From: Simon Davis
Sent: 05 February 2019 17:17
To: [REDACTED]
Cc: [REDACTED]
Subject: RE: Highfield Rd BR/215/18/PL

Subject: Highfield Rd

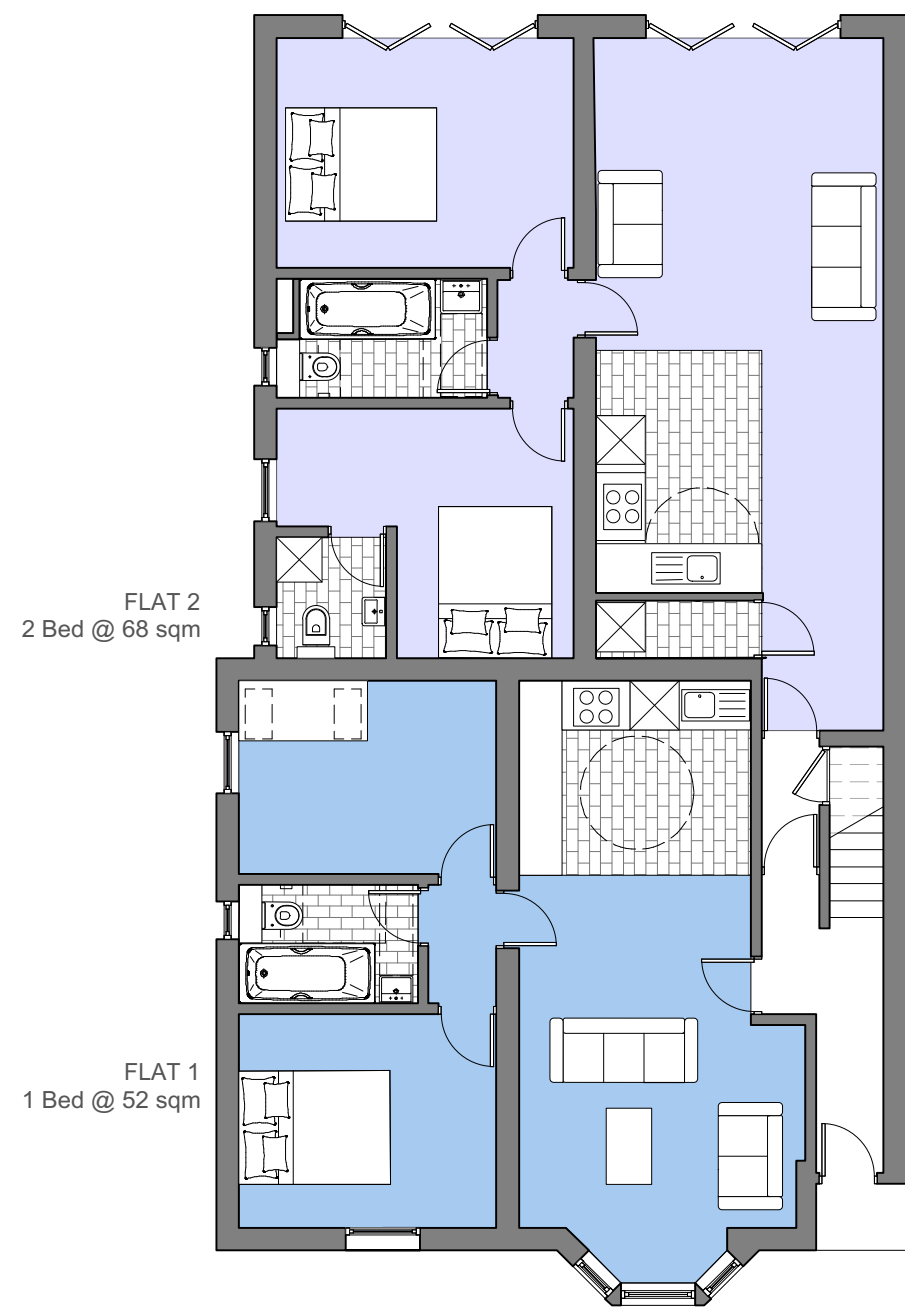
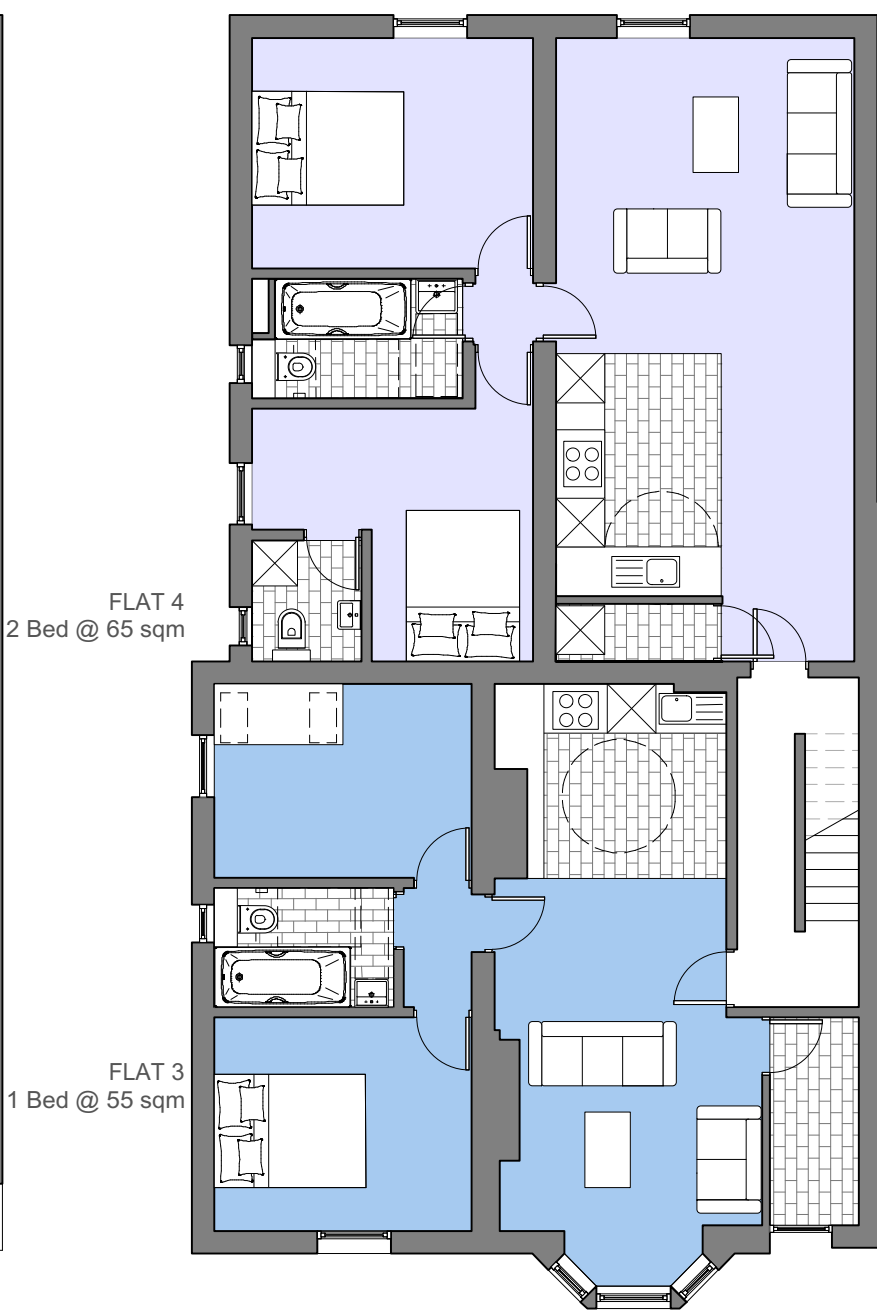
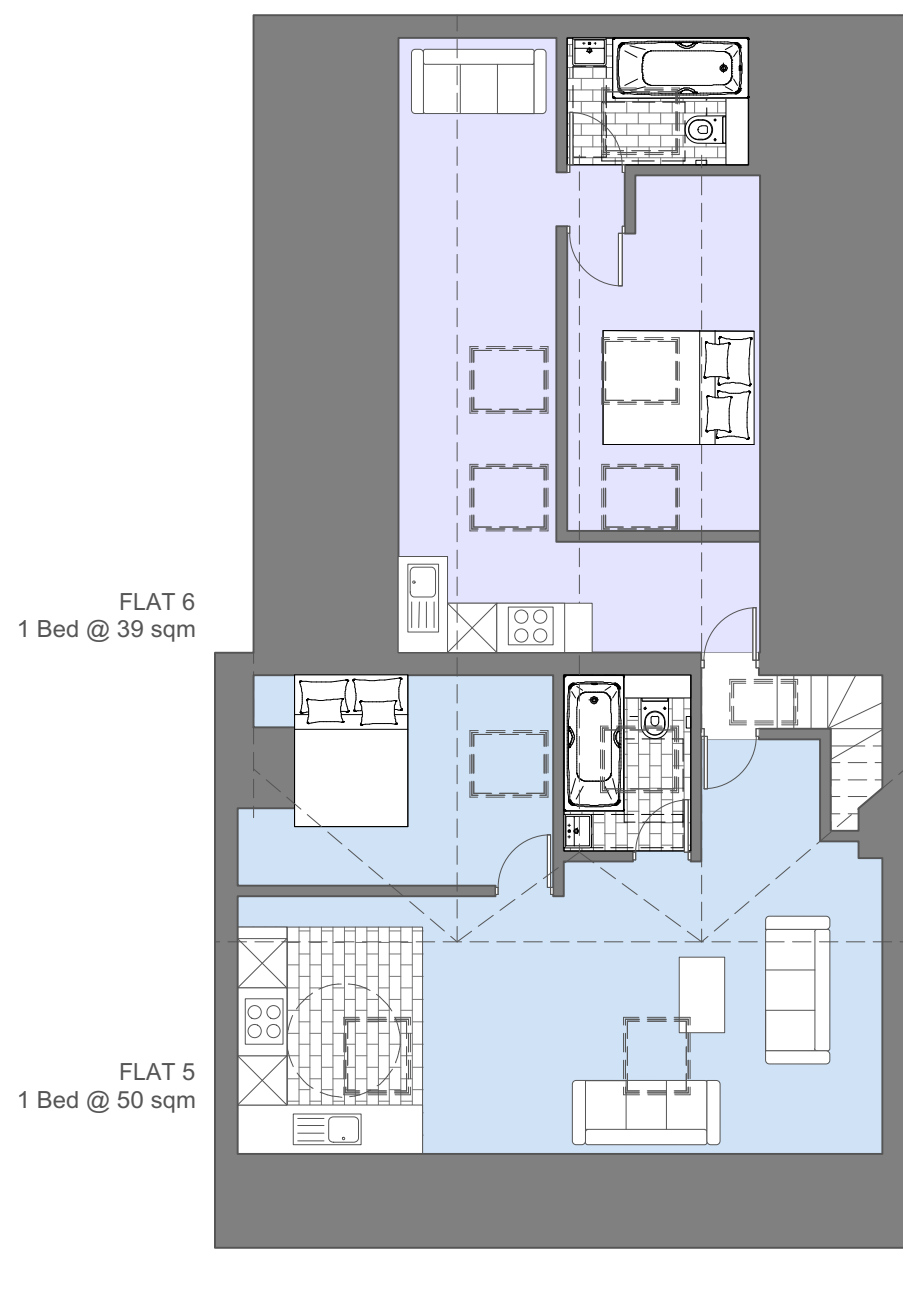
However, I have discussed this with our Group Head of Planning and although the national space standards do state that "Furnished layouts are not required to demonstrate compliance", we do not agree that this should be applied across the board and therefore, regardless of how the accommodation layout is shown (i.e. bed or desk), we should calculate the area requirements by size of room.

The standards say that a double is at least 11.5m² and a single at least 7.5m². I have therefore recalculated the requirements based on the size of the rooms and this means that now only 2 of the flats do not comply (see new table below). Clearly the two that do not comply are those that you suggest will be studies but we need to ensure that if the owner/occupier uses them as bedrooms then there is sufficient space elsewhere for their needs. We would be happy to defend this position on appeal.

Flat	No. Bedrooms	No. Persons	Requirement m2	Proposed m2 (using your measurements)	Complies?
1	2	2	61	52	N
2	2	3	61	68	Y
3	2	2	61	55	N
4	2	2	61	65	Y
5	1	1	39	50	Y
6	1	1	39	39	Y

Many thanks for your time on Friday. As discussed please find attached revised plans indicating we have met minimum space standard requirements as annotated with the transference of single bedrooms to studies.
